RE: Review Comments for Final Plan – Administrative Review

Project Name: Riverside Wood/Millwork Shop
Project ID: 10-79900010
Project Address: 828 Riverside St CBL: 325-B-008-001
Planner: Erick Giles, AICP, LEED AP

2 SITE PLAN
SCALE: 1" = 10'

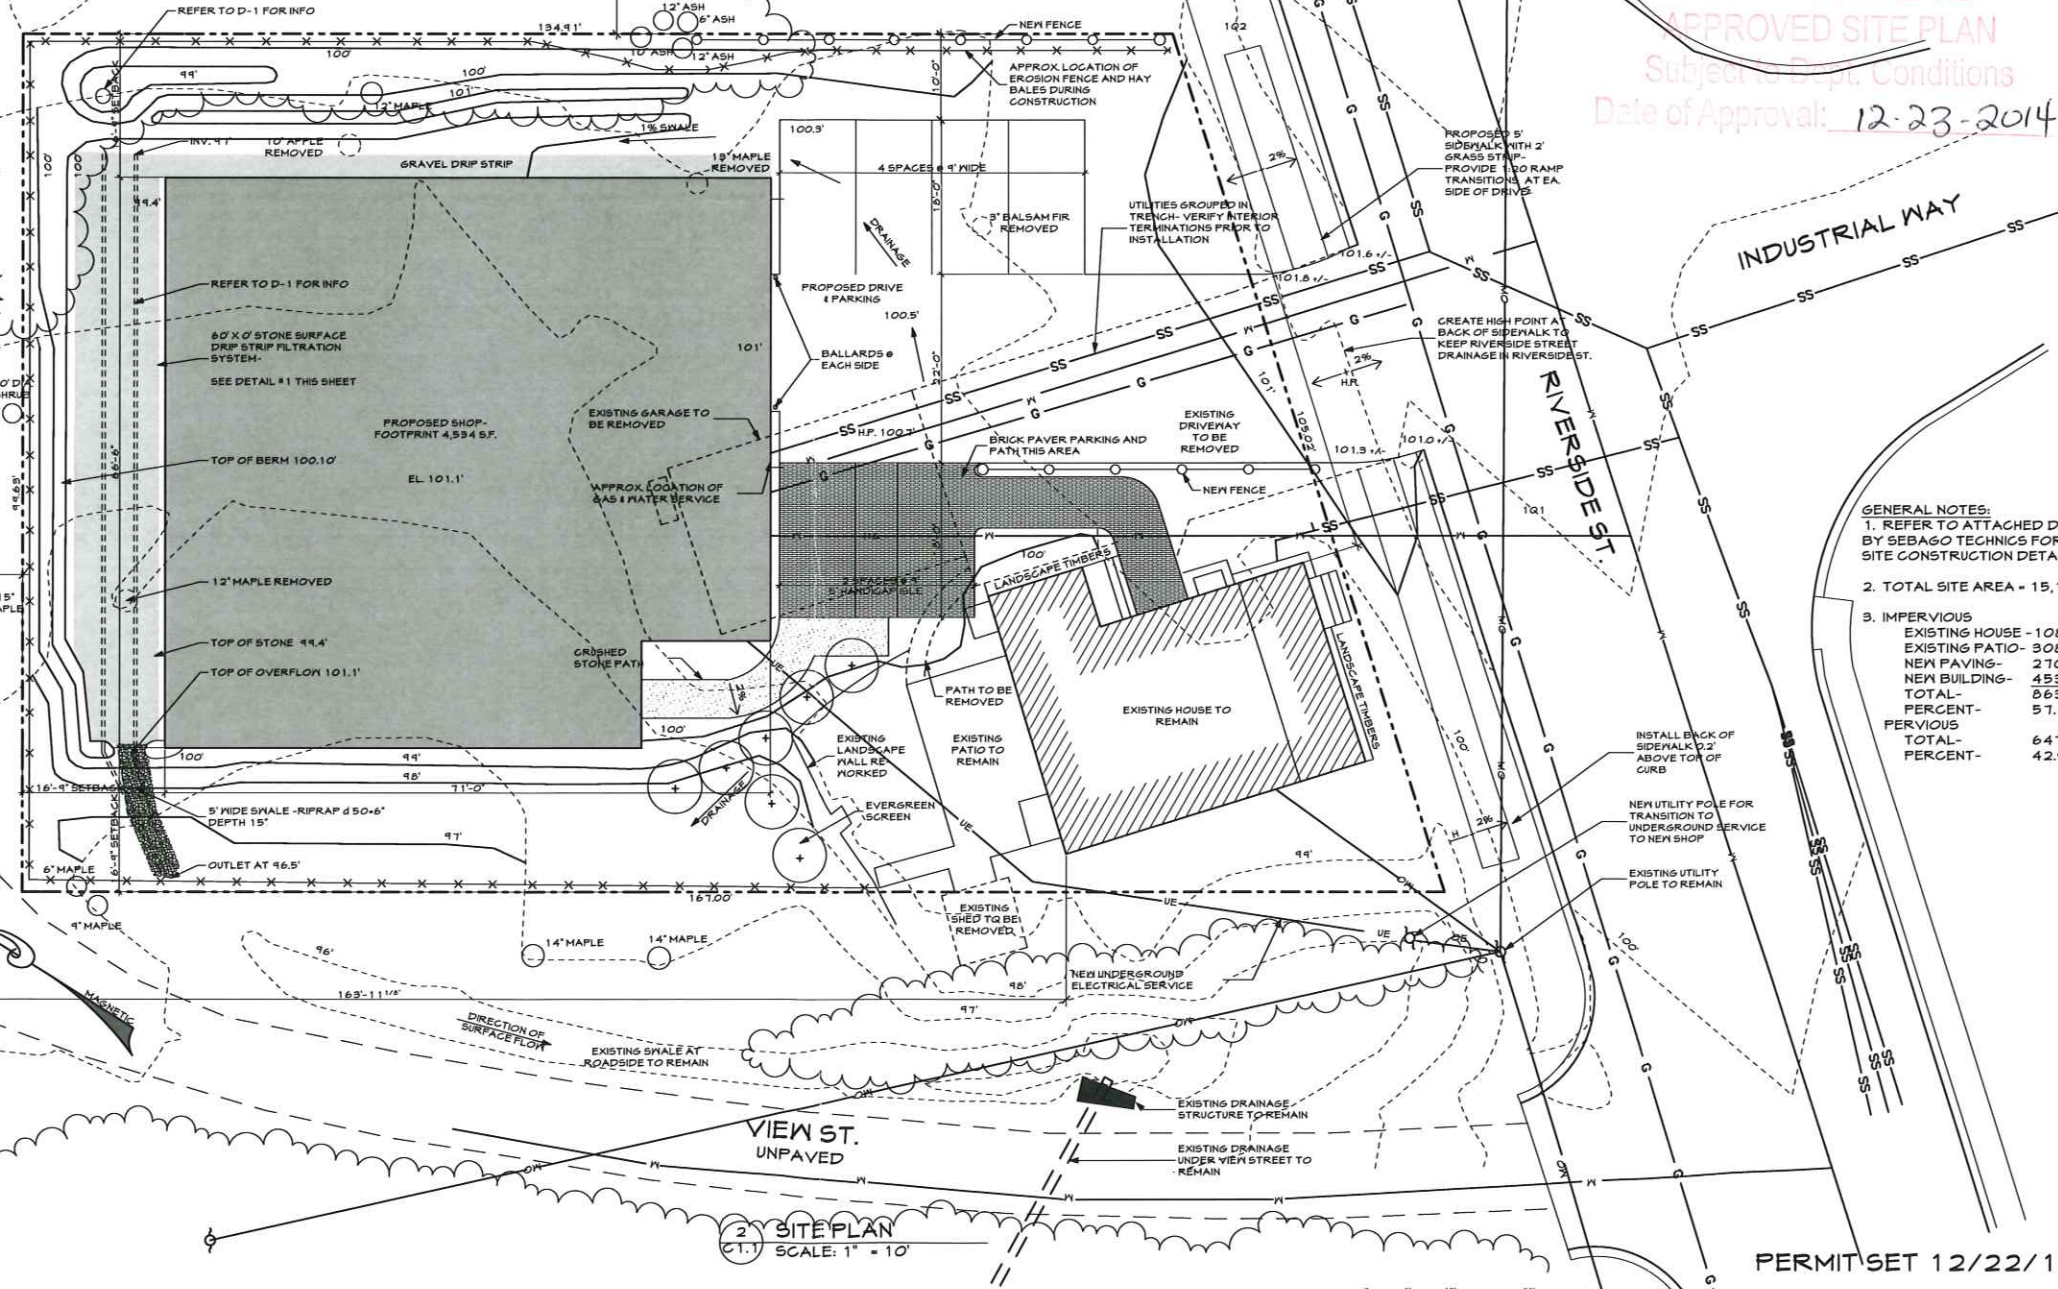
- i. Applicant needs to apply for a sidewalk waiver if they do not intend to install a sidewalk.
- ii. Applicant current shows an approximate 10' x 10' shed within the View Street R-O-W. Applicant shall indicate that this shed will be moved onto the applicant's property within the required 10' setback line.
- iii. Applicant indicates the existing 25' wide driveway will be removed and replaced with a 20' wide driveway. Does the applicant intend to alter the curb cut to the street?
- iv. The applicant is requested to show how drainage from the site will be handled.

- v. The applicant is requested to show utility (water, sewer, electric) locations and details for installation. Details for work within the road right of way can be provided upon request.

- i. The proposed parking aisle width is 20 feet and does not meet City of Portland standards. The applicant should provide justification for a technical waiver from the standard.
- ii. It is unclear how wide the proposed parking spaces will be. This should be clarified.

DRAINAGE ANALYSIS PLAN

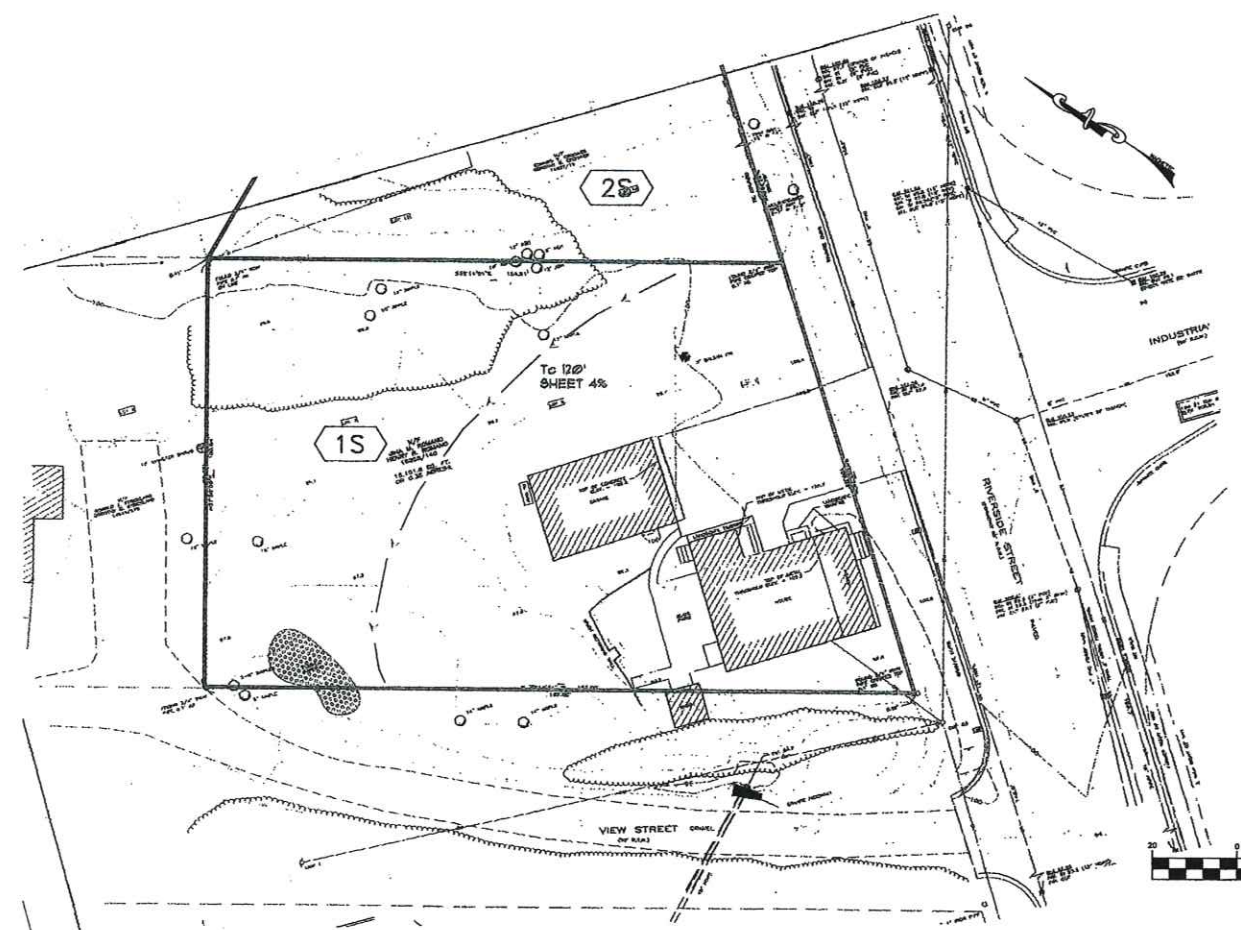
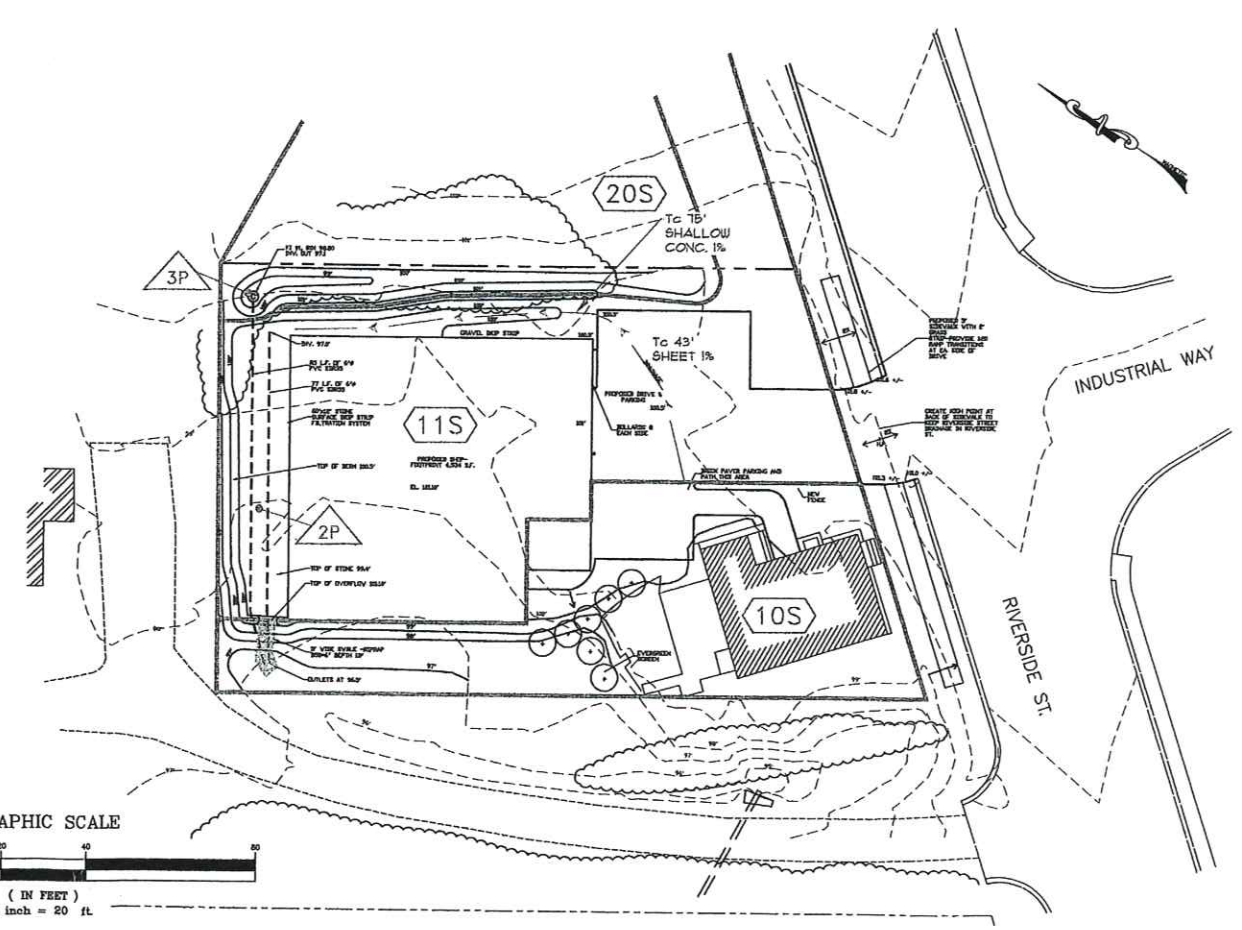
Applicant needs to provide a stormwater analysis that includes a description of the new impervious surface being created and a management plan for how drainage discharge will occur and the method of any proposed treatments.
